Planning Officer: Lynnyrd Wolfe

Planning Application Ref: A/99/19/TC

Location: Angmering Manor Hotel, High Street, Angmering

Description of works: Reduce 2no limbs on south/south east aspect by approx. 4m to 1no. holm oak tree within the Angmering Conservation area

Angmering
manor
Hotel

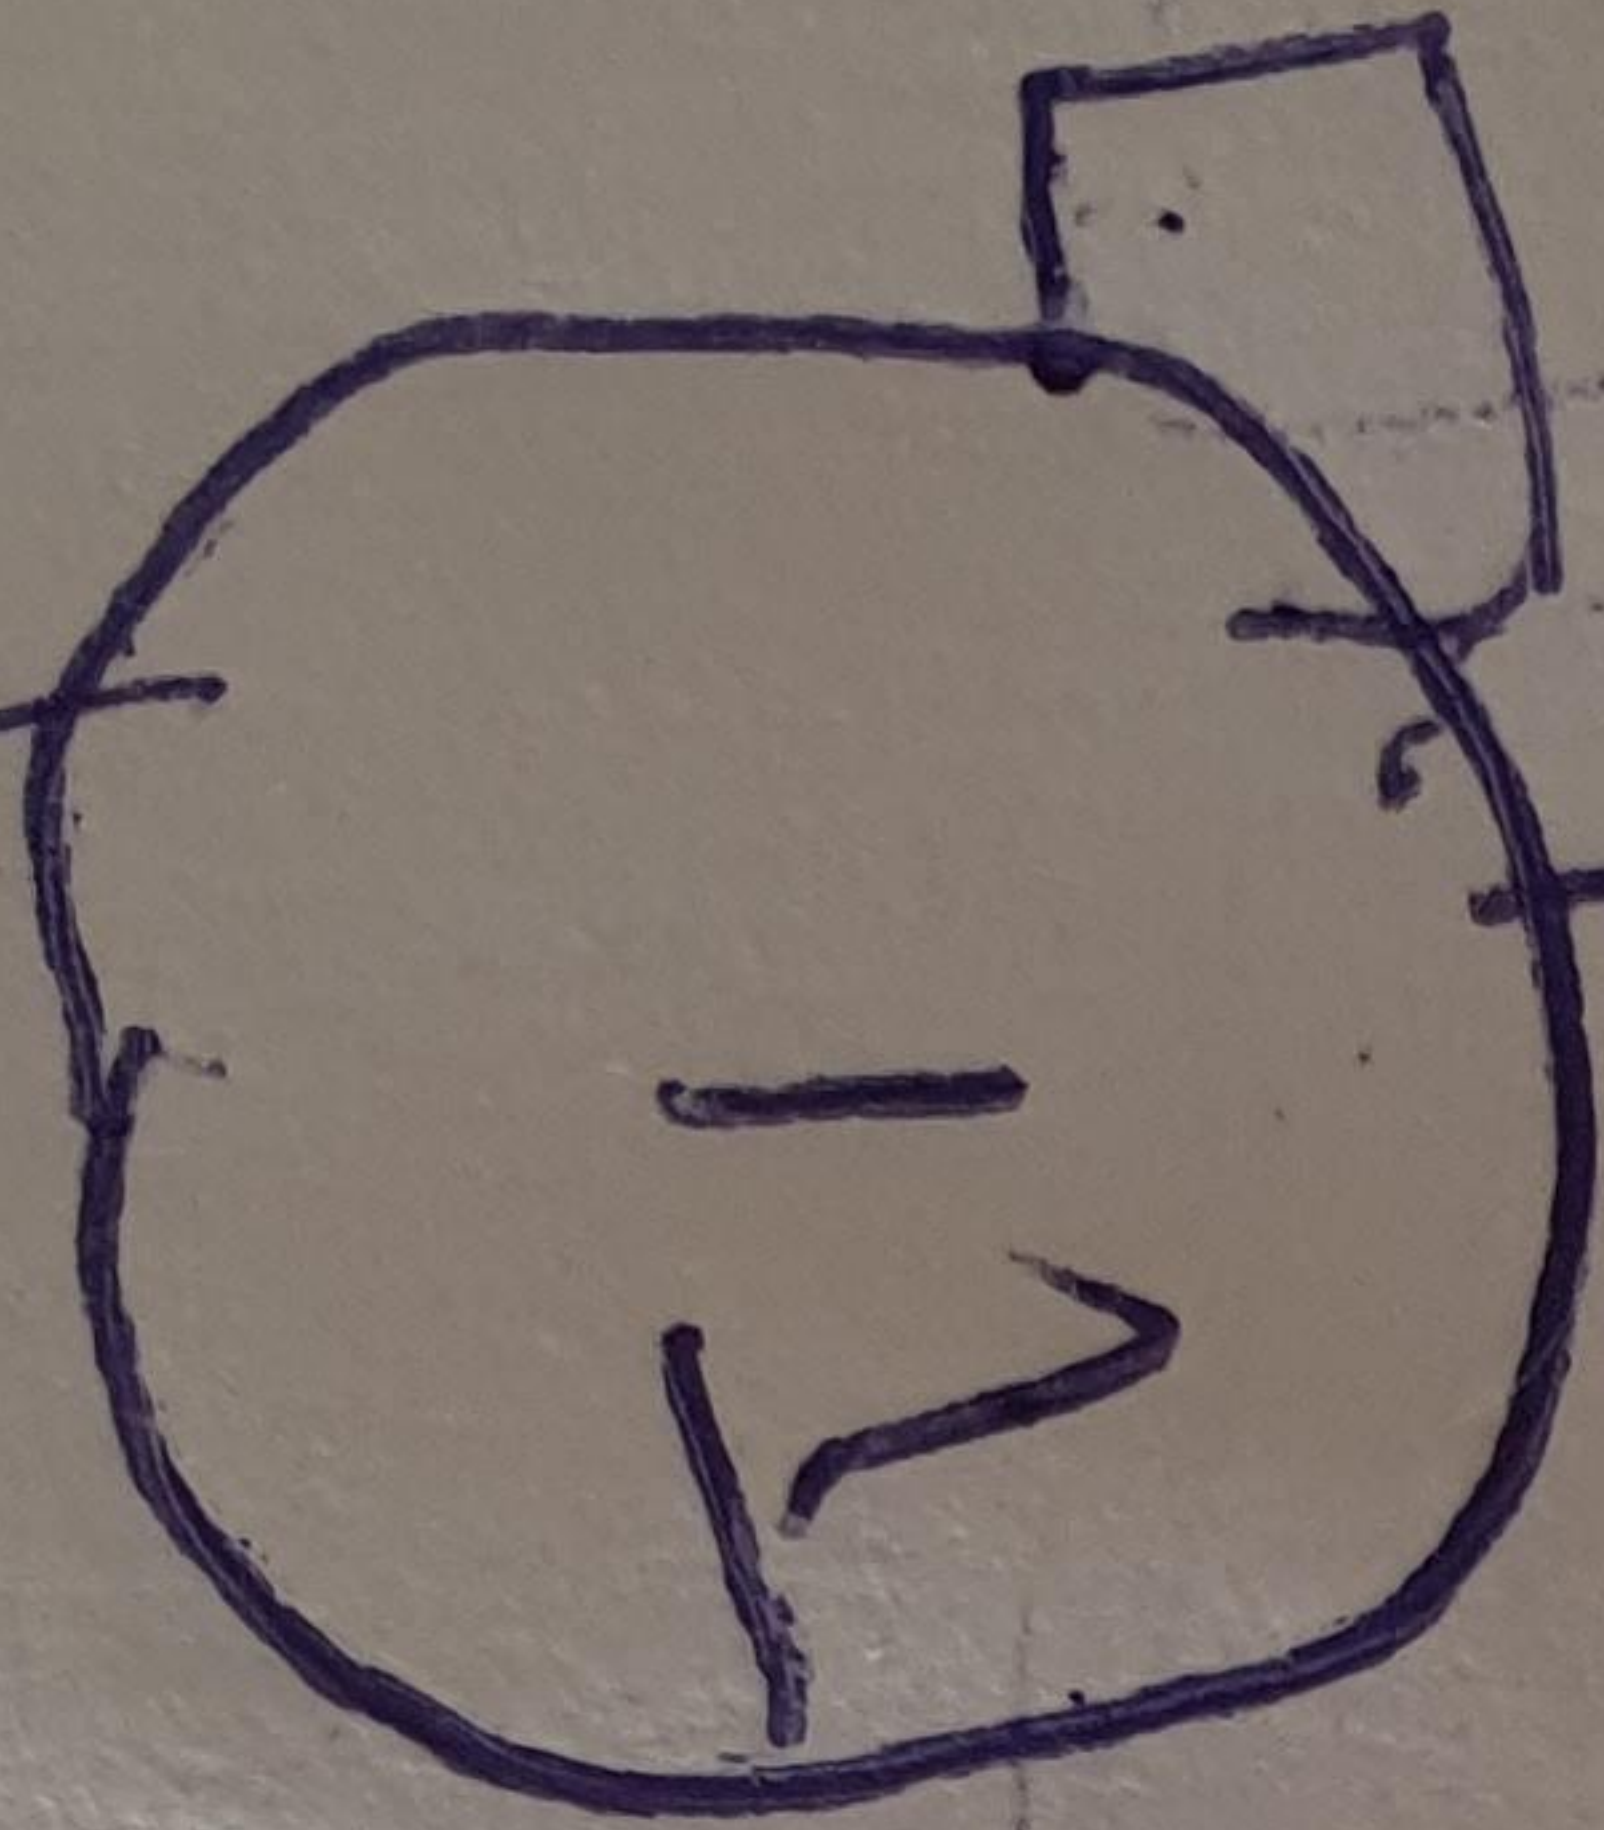
- This is a large and aged example of its type, with a correspondingly complex crown and management history.
- It appears to be outwardly sound and stable with an attractive crown profile. It is prominent within the ornamental grounds of the hotel and can be seen from surrounding properties.
- The applicant has proposed to cut back heavy limbs growing over their property, to such an extent that no leaf-bearing twig structure would remain and large wounds be created. Such work may jeopardise the long-term survival of those limbs as they may not be able to produce enough new growth to sustain themselves nor be able to resist the ingress of decay-causing organisms.

- This veteran tree requires careful management that respects its age and vulnerability to environmental changes and disease progression.
- The applicant proposes an approximate 4metre reduction in lateral spread of limbs. This would exceed the recommendations in British Standard 3998:2010 – Tree Work and be likely to result in harm to the health and vitality of the tree with large pruning wounds being formed as well as undermining its visual amenity value and impact in the landscape.

- I register an **OBJECTION** to the work proposed and recommend the making of a Tree Preservation Order to preserve its place in the landscape and better control its future management. I attach a TEMPO form and GIS plan for this purpose.
